TRAFFIC IMPACT STUDY

Retreat at PrairieRidge Filings 1-3 Preliminary Plan & Rezones
El Paso County, Colorado
PCD File No. P2313, P2314, P2316, & SP239

November 2023
Revised March 2024

RETREAT AT PRAIRIERIDGE FILINGS 1-3
PRELIMINARY PLAN
FILING 1 & 2

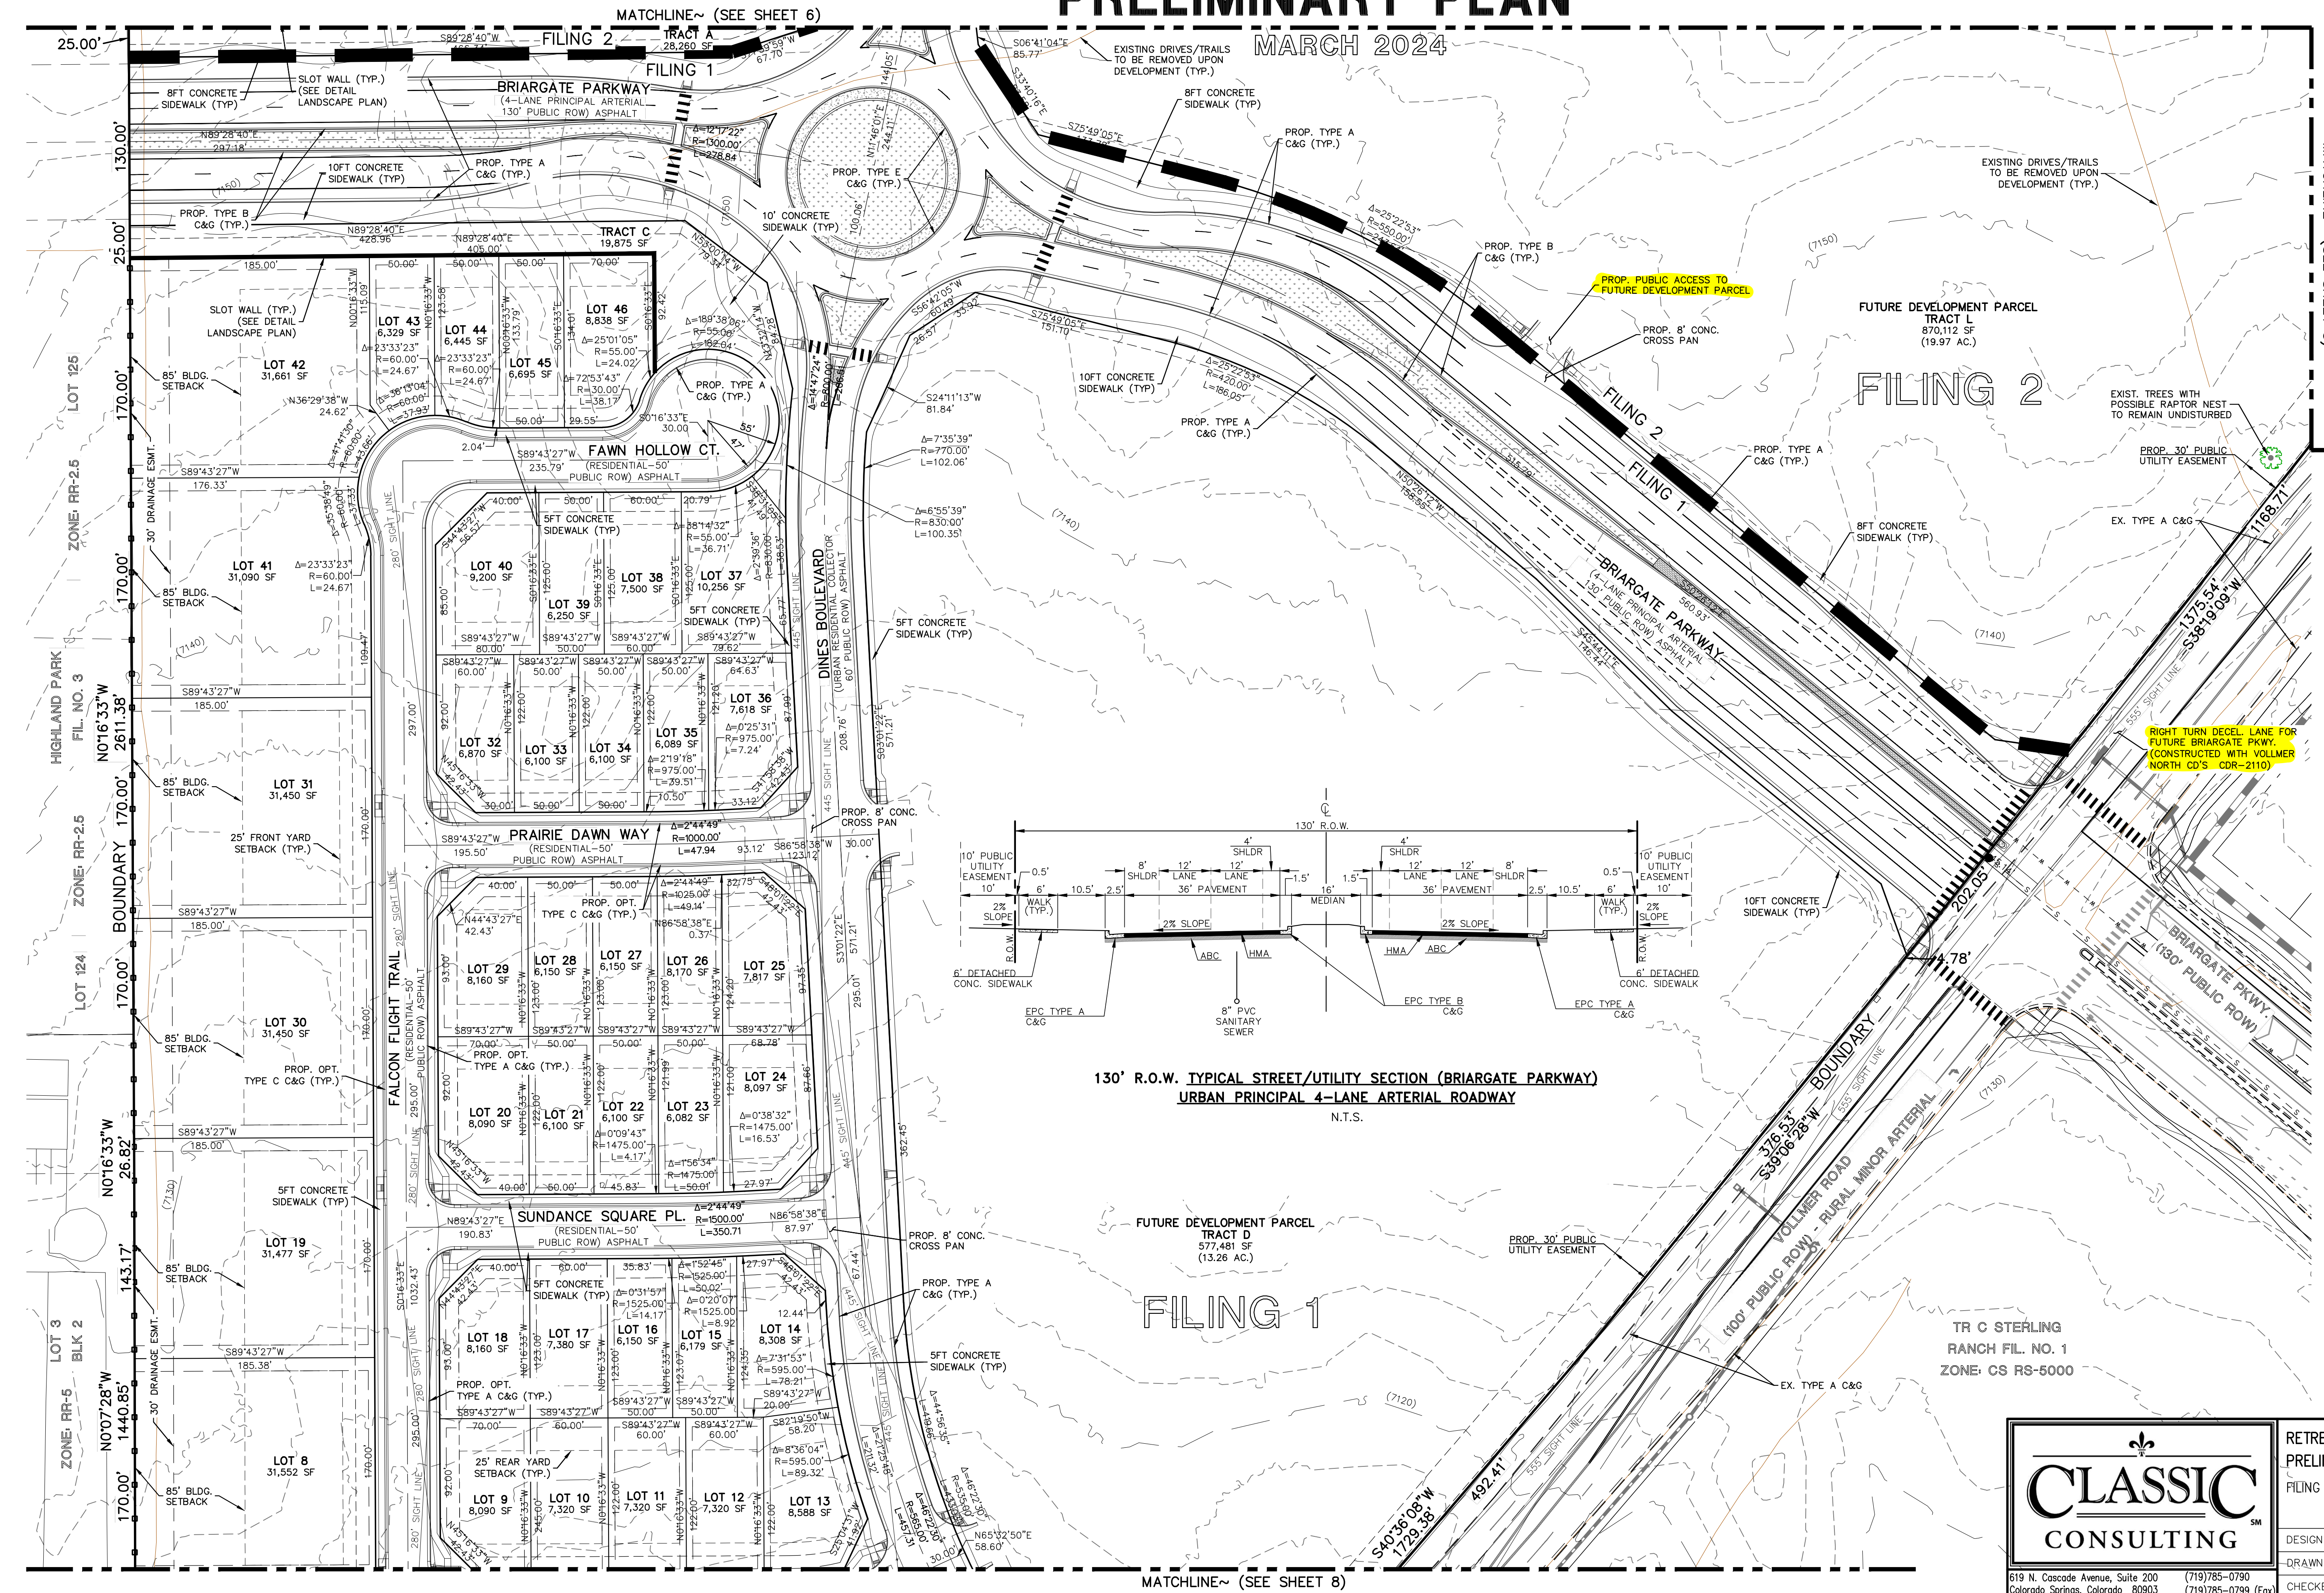
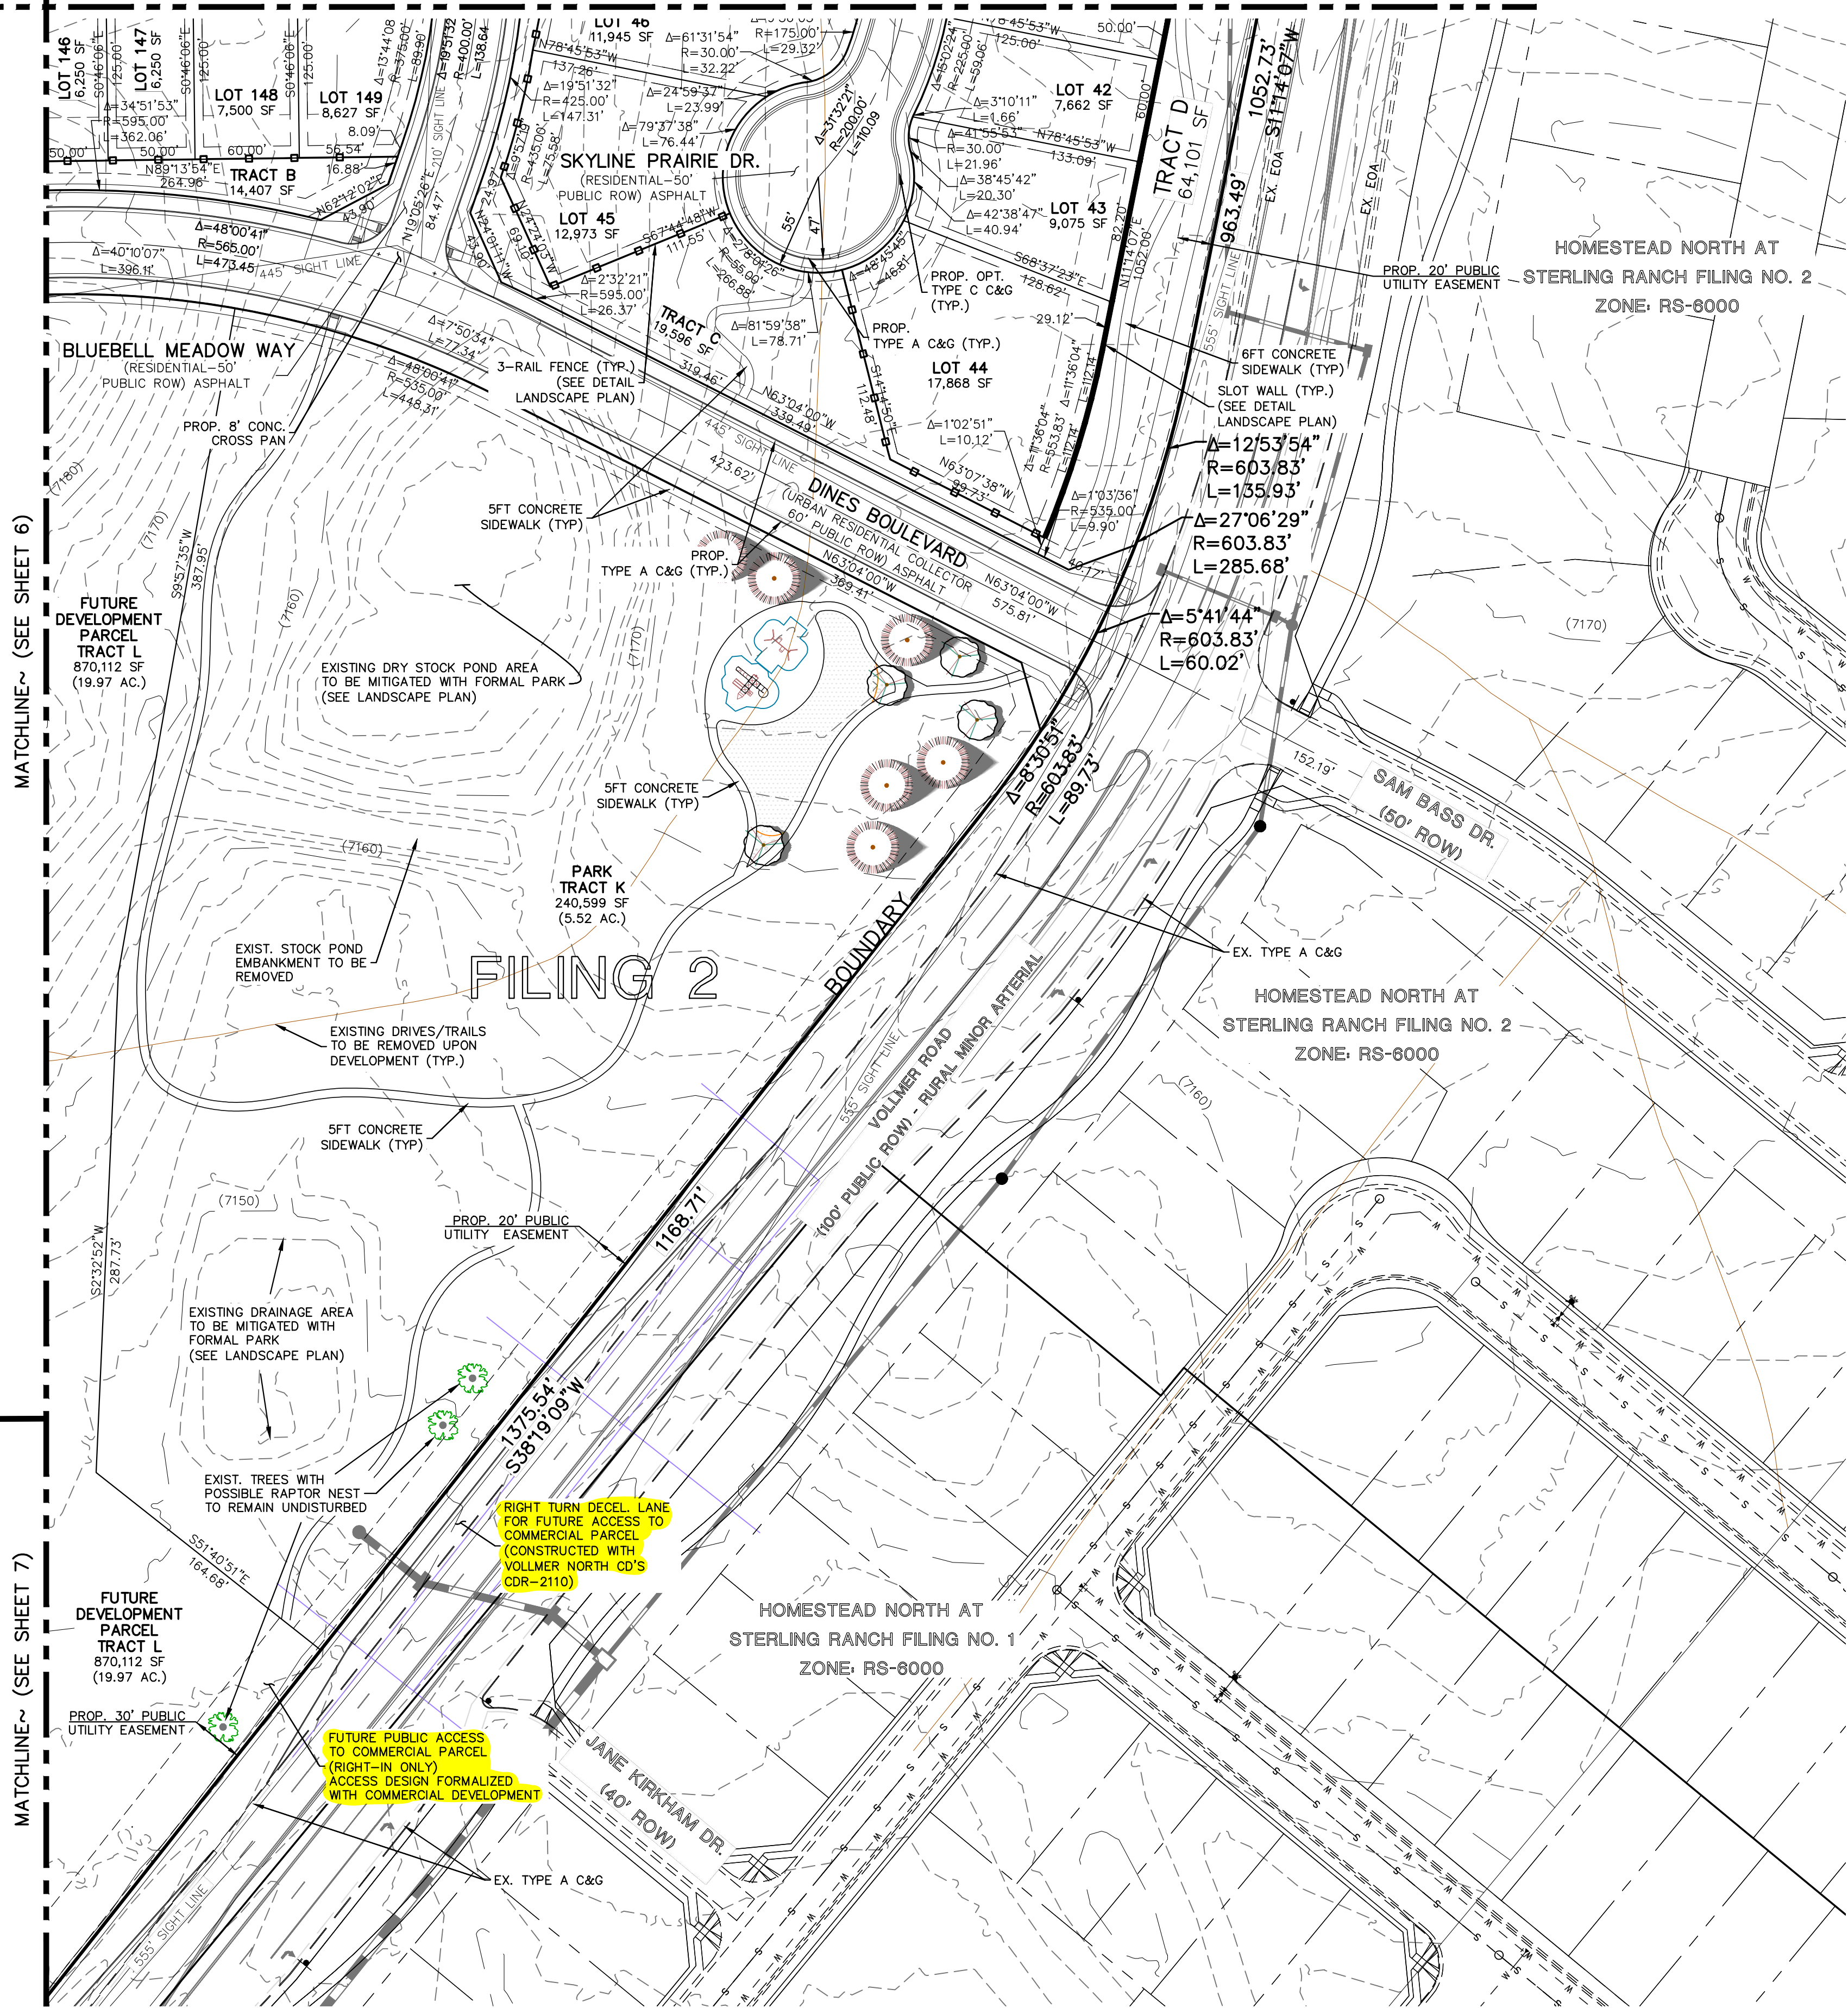
Per ECM Section 2.2.4.B.2 no direct lot access is allowed from a principal arterial

Per ECM Section 2.2.5.B, intersection spacing for a principal arterial is 1/2 mile. Please provide deviation for the spacing length.

Per ECM Section 2.2.5.B, intersection spacing for a rural minor arterial is 1/4 mile. Please provide deviation for the spacing length.
